**Planning Application No: 3/2026/0028**

**Proposal: Proposed alterations to the site entrance including boundary wall amendments and a new gate.**

**Location: Aysgarth Ribchester Road Clayton Le Dale BB1 9EG**

SHEET:
EXISTING AND PROPOSED
ELEVATIONS

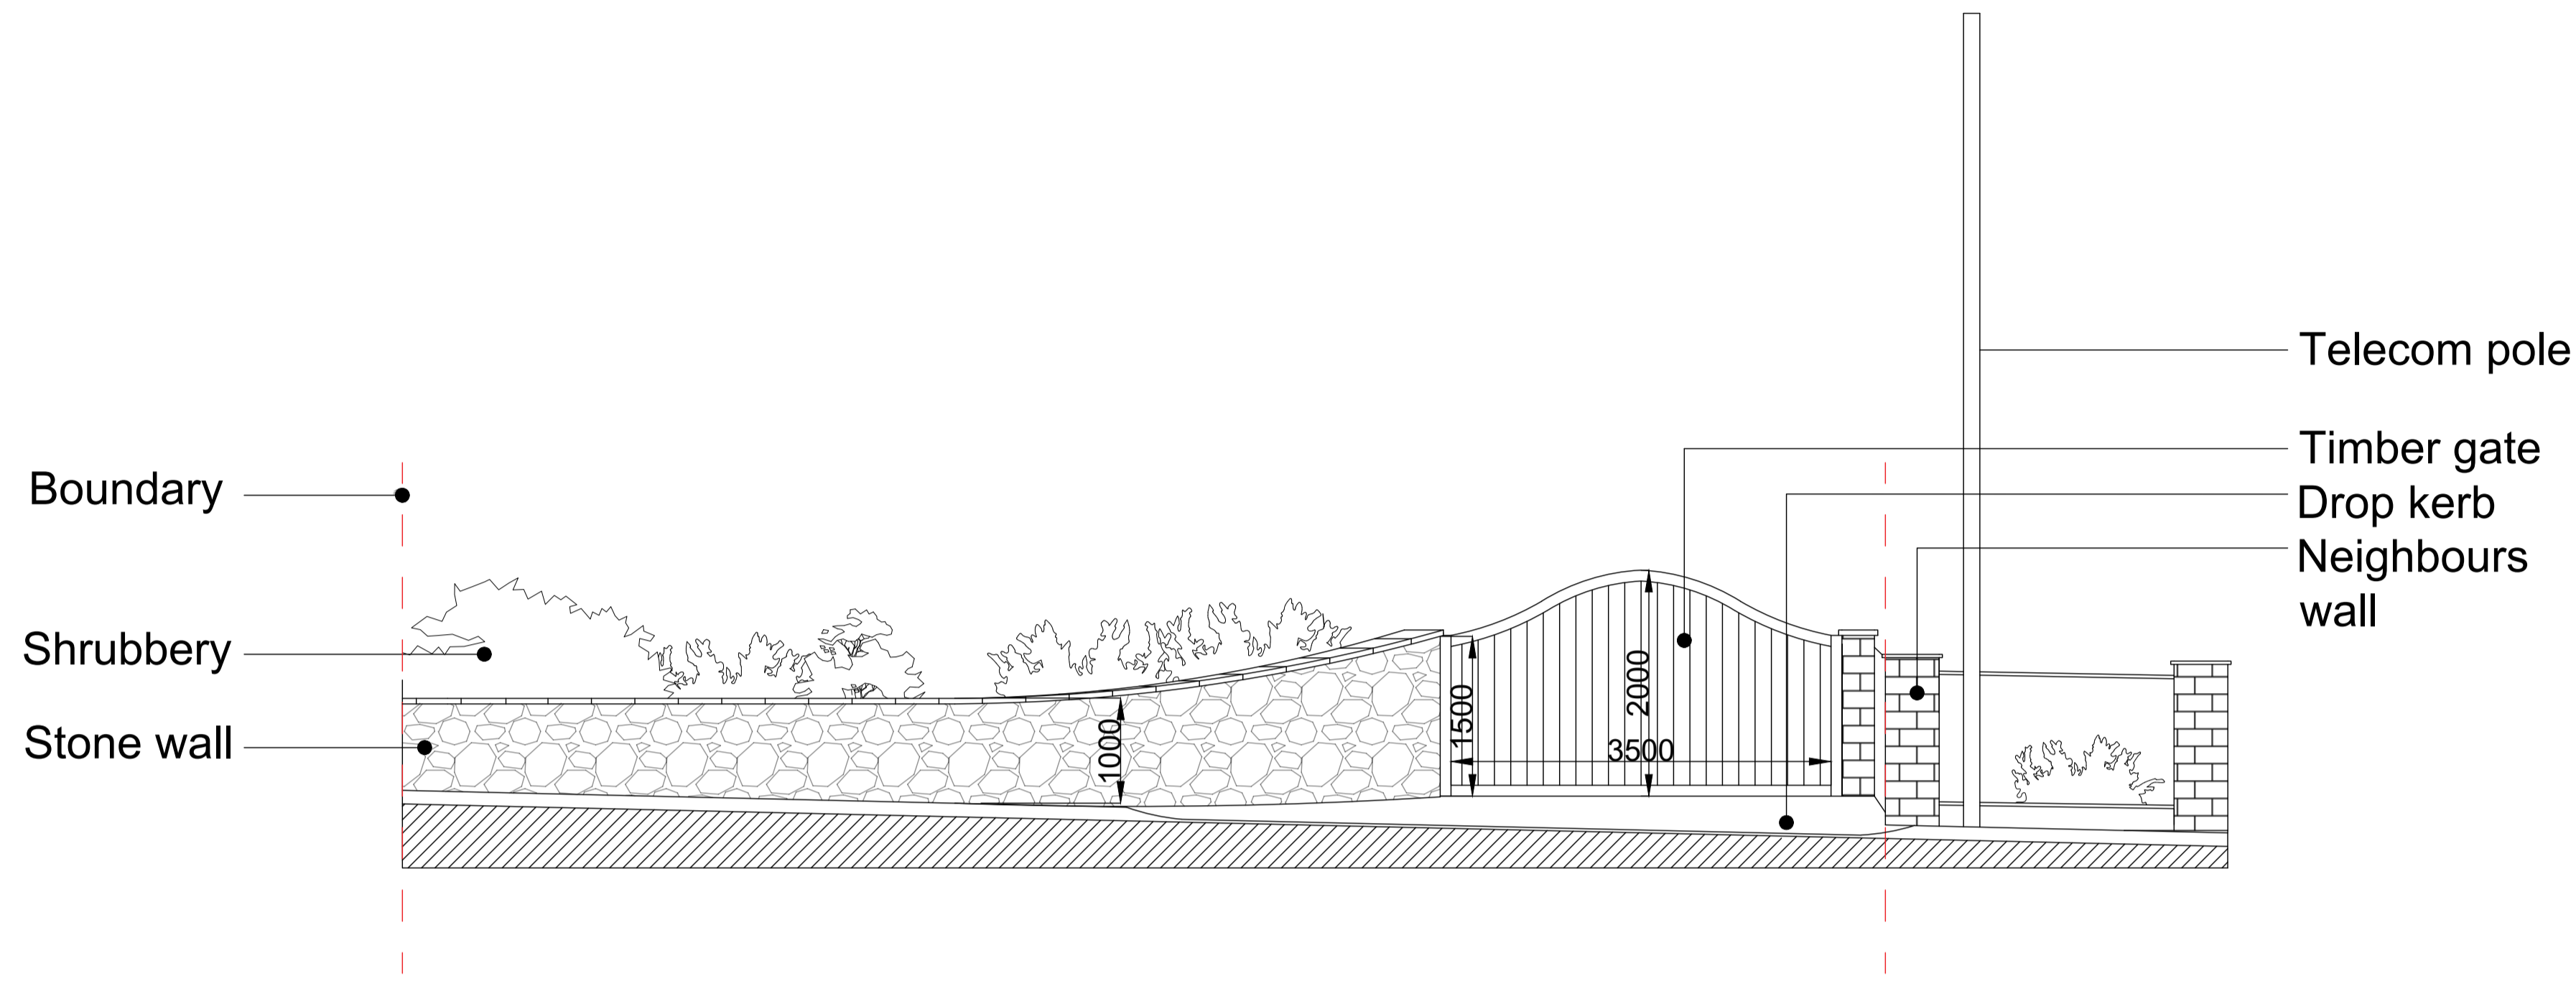
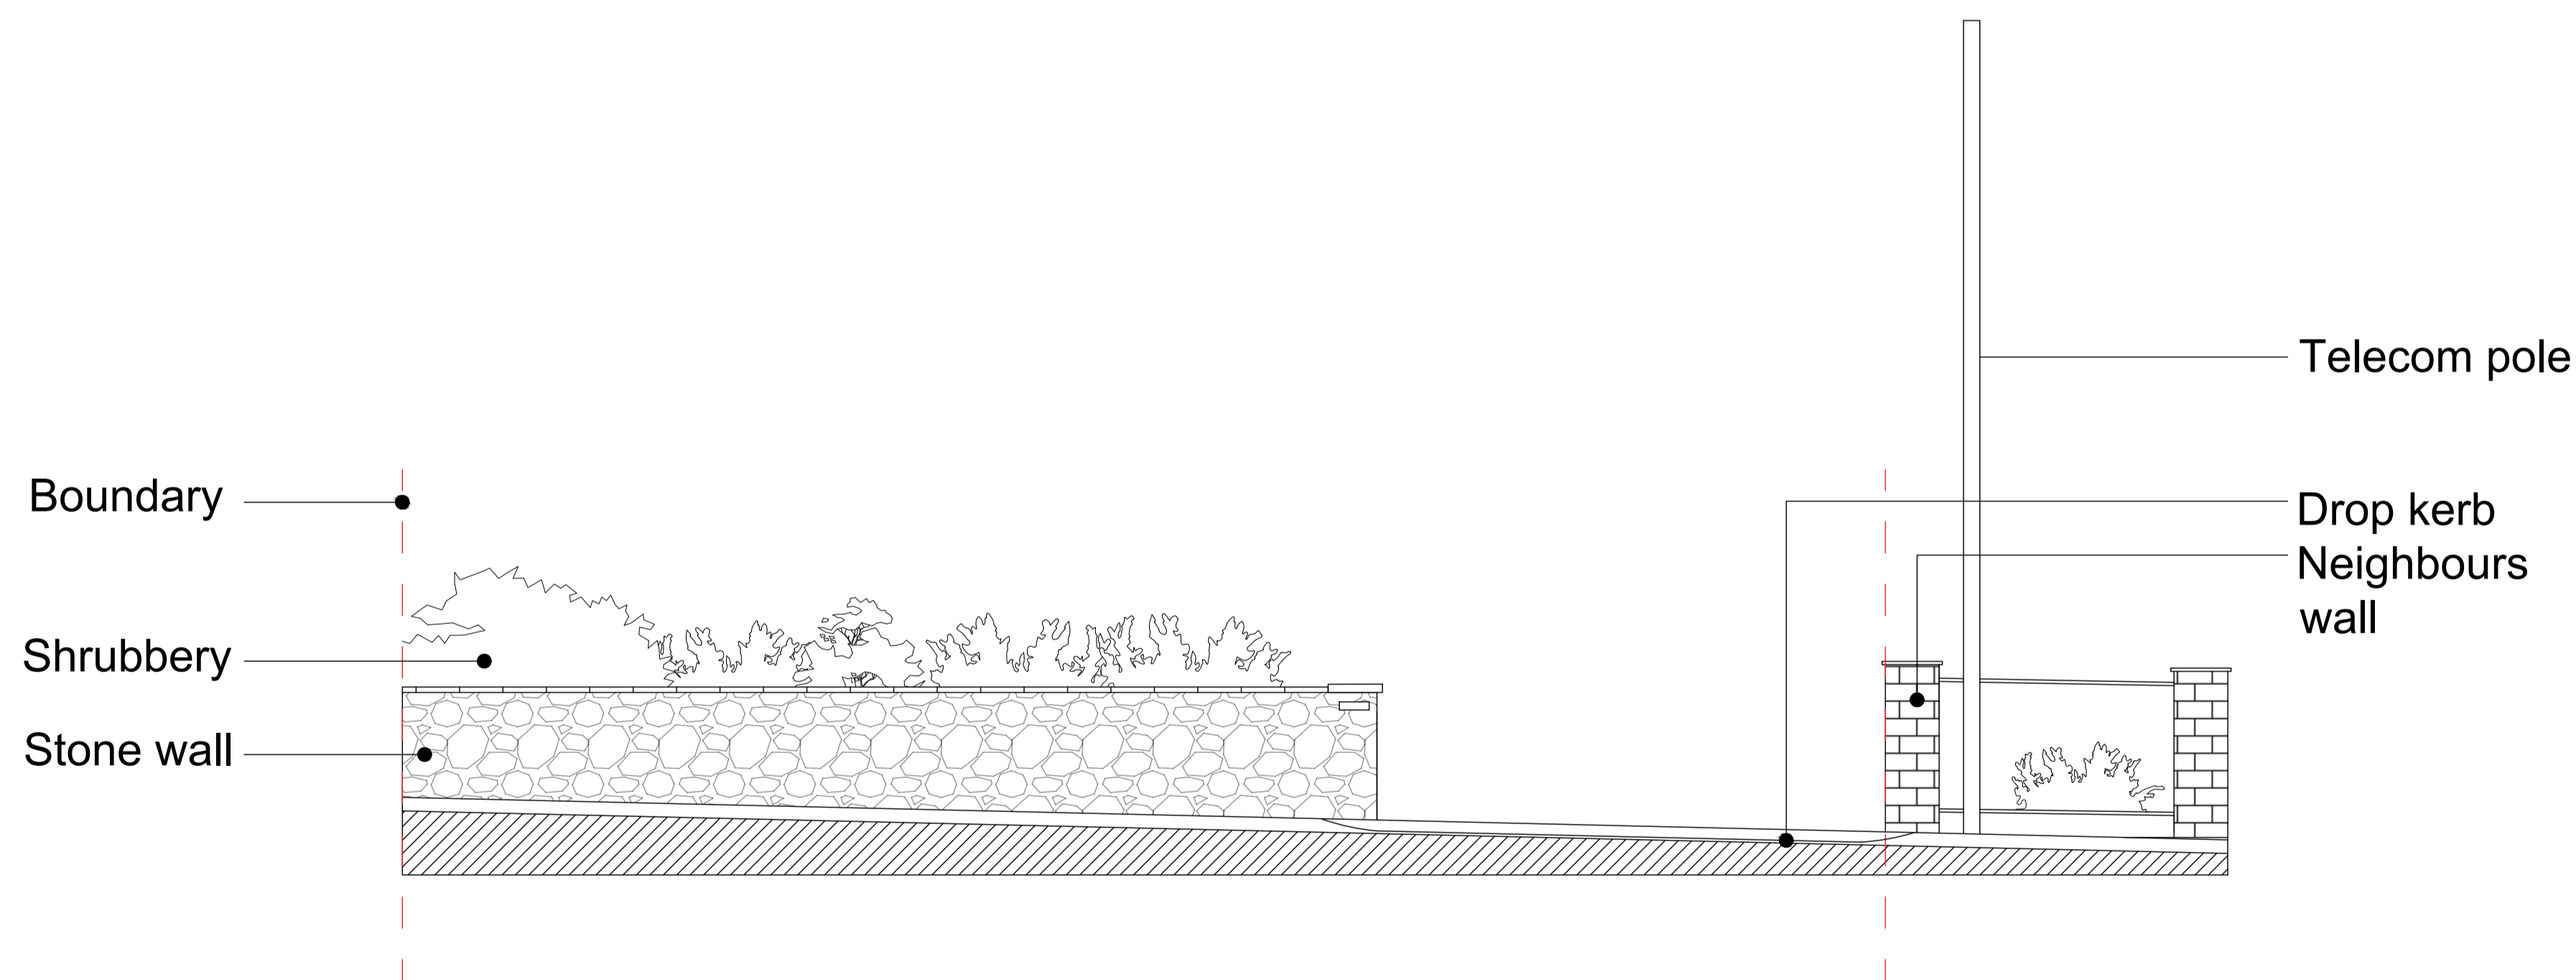
The dwelling is accessed off Ribchester Road which is a B classified road subject to a 30mph speed limit. The boundary wall will be altered to form the new access ref. Existing and proposed elevations PHA/1082, 14.01.26, drawing A1.2 submitted. To undertake the works to the access, the Applicant needs to apply for a vehicular crossing application, please see the informative below for more details.
